Application No: K/6/22/PL
Site Address: 47 Golden Avenue East Preston BN16 1QX
Description of works: Erection of a detached dwelling and integral garage (resubmission following K/51/21/PL). This application is in CIL Zone 4 and is CIL Liable as new dwelling.

Thank you for your internet representation made on 30th March 2022 which has been recorded as an objection with the comments as follows:

FRONT ELEVATION

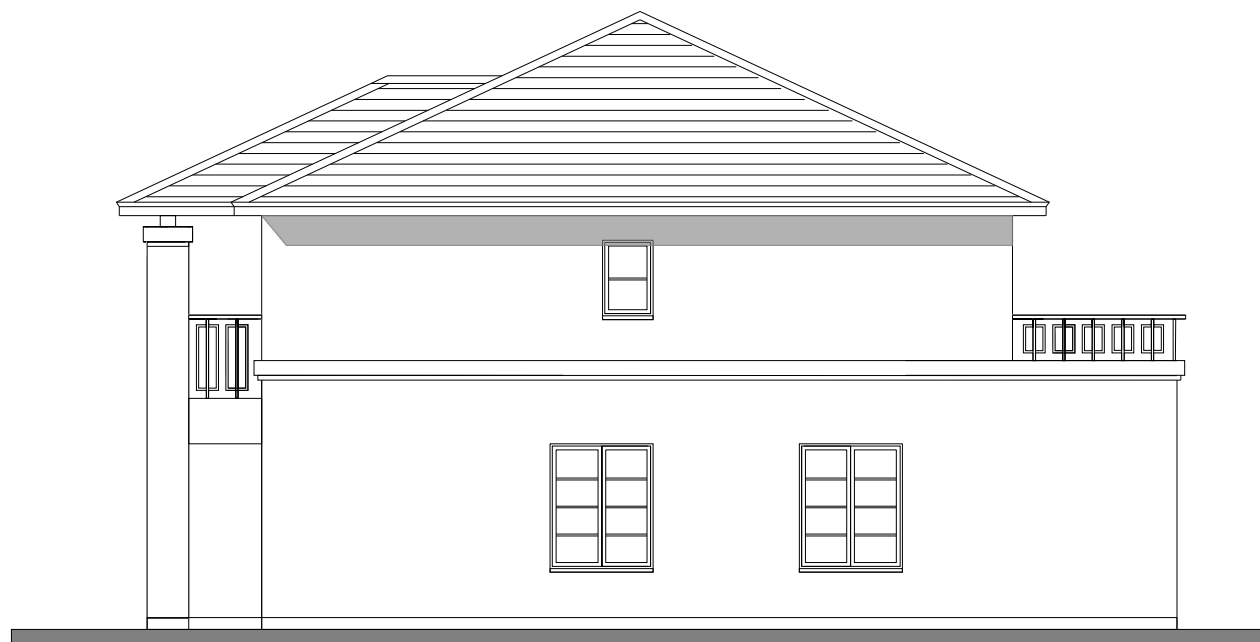
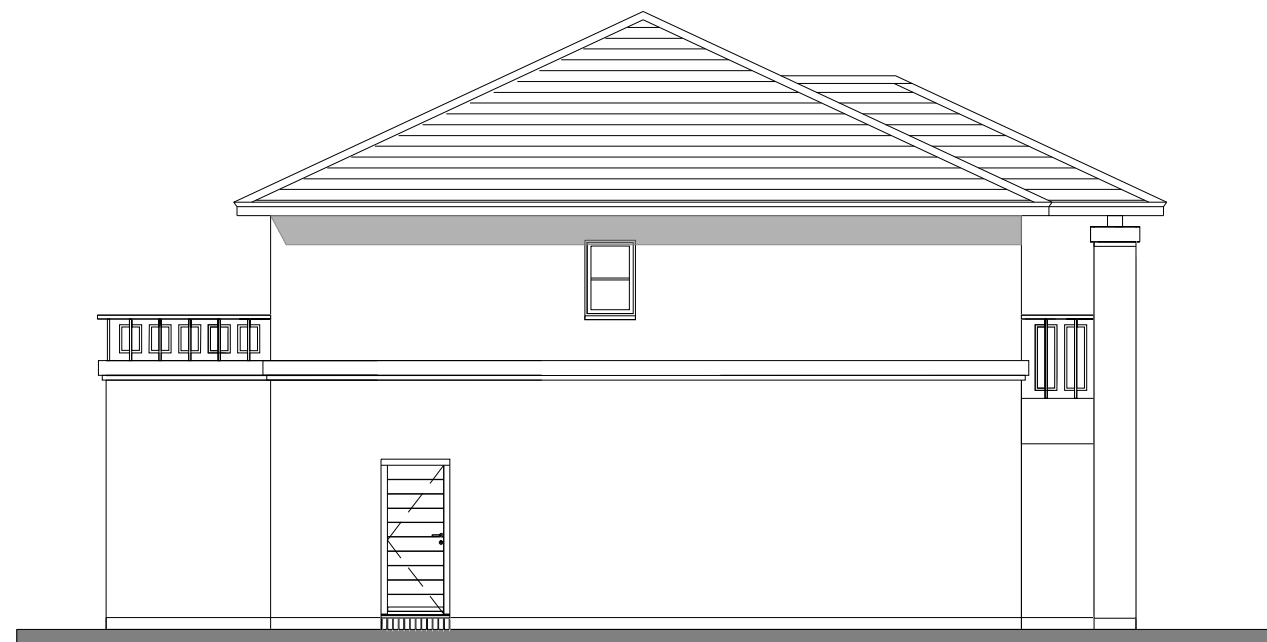
I write on behalf of the East Preston and Kingston Preservation Society, which has no objection to the projected house design. However, we would ask that due consideration be given to the materials proposed. The unrelentingly monochrome palette would be out of keeping with nearly all surrounding properties, which are in traditional brick, tile hanging, brown/terracotta roof tiles, with occasional timber boarding. In this respect it might breach Policy 7 (1i) of the Kingston Neighbourhood Plan and Policy D DM1 of the Arun Local Plan. We also have concerns about surface water drainage on the site. The previous application specified a resin bonded front driveway (possibly breaching Policy 7 (2i) of the Kingston Neighbourhood Plan). Has the Drainage Engineer been consulted about this, and generally about this application? If the above points could be satisfactorily addressed, we would have no objection to this application.
